# *City of Albuquerque*

RE: NARAGHI RESIDENCE (L-23/D12A) ENGINEER'S STAMP DATED 10/13/94

Based upon your 10/14/94 submittal, the following concerns will need to be addressed prior to authorizing Building Permit approval.

**GRADING AND DRAINAGE PLAN
NARAGHI RESIDENCE**

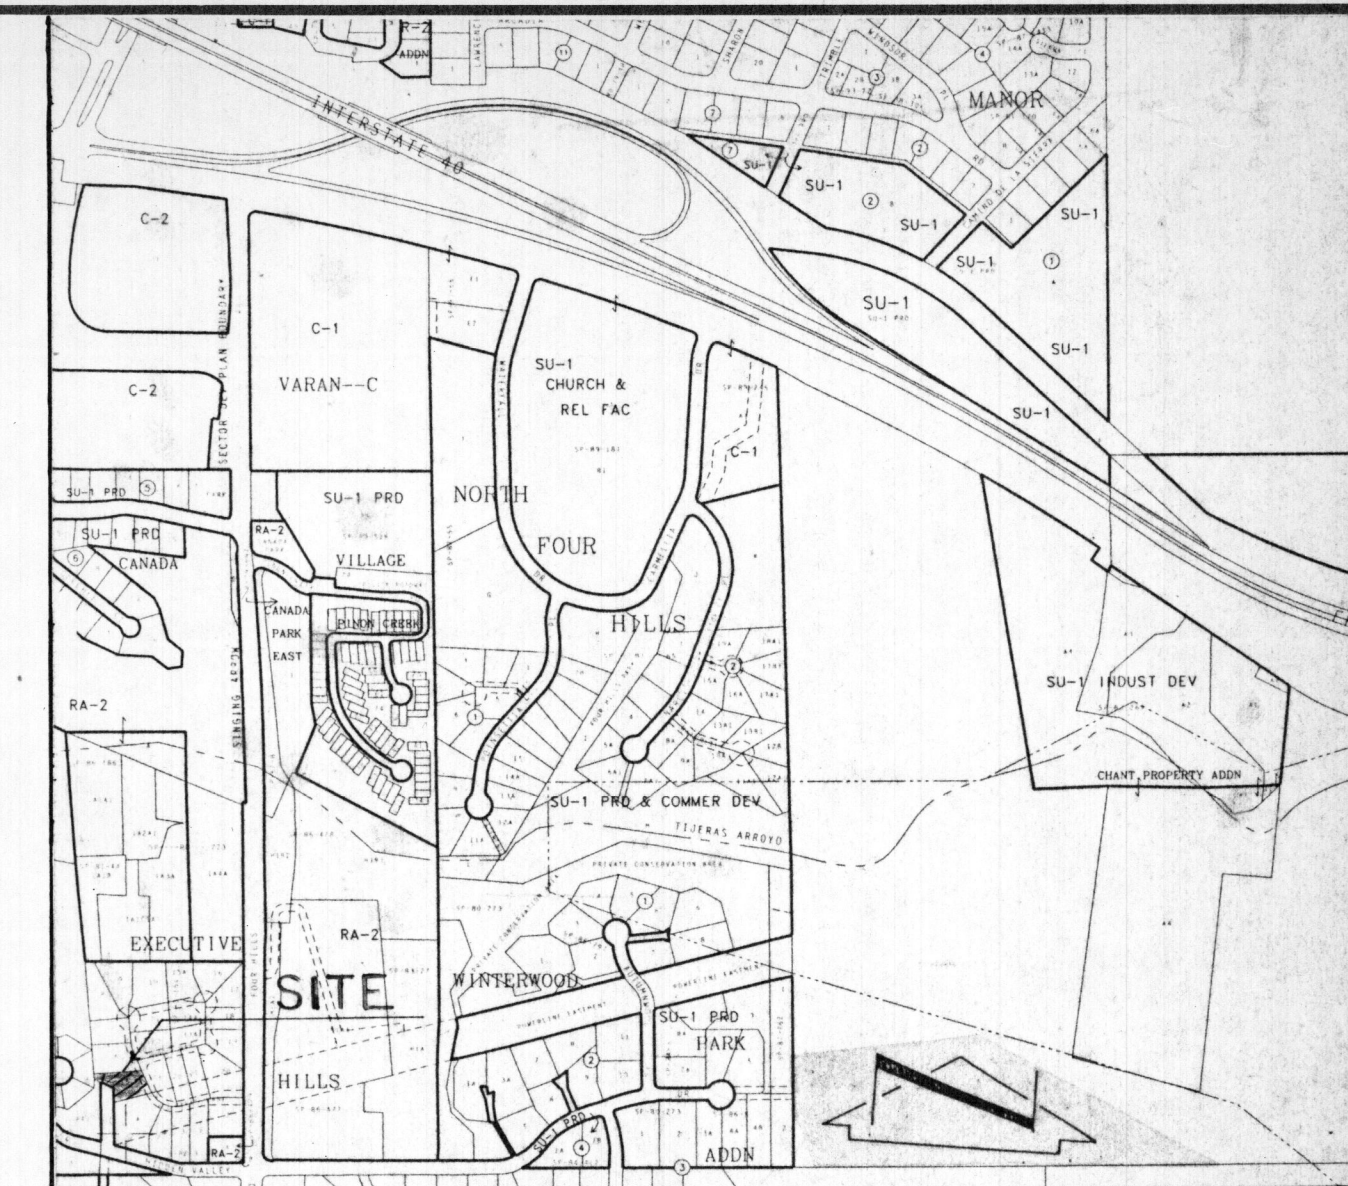
1. The approved Executive Hills Subdivision Master Drainage Plan calls for developed flows (roof & paved areas) from Lot 5 to be routed to Executive Hills Lane. The existing ponding areas shown on your plan are to accept storm flows from unimproved portions of the lot only. Your plan will have to be revised to reflect this drainage scheme.
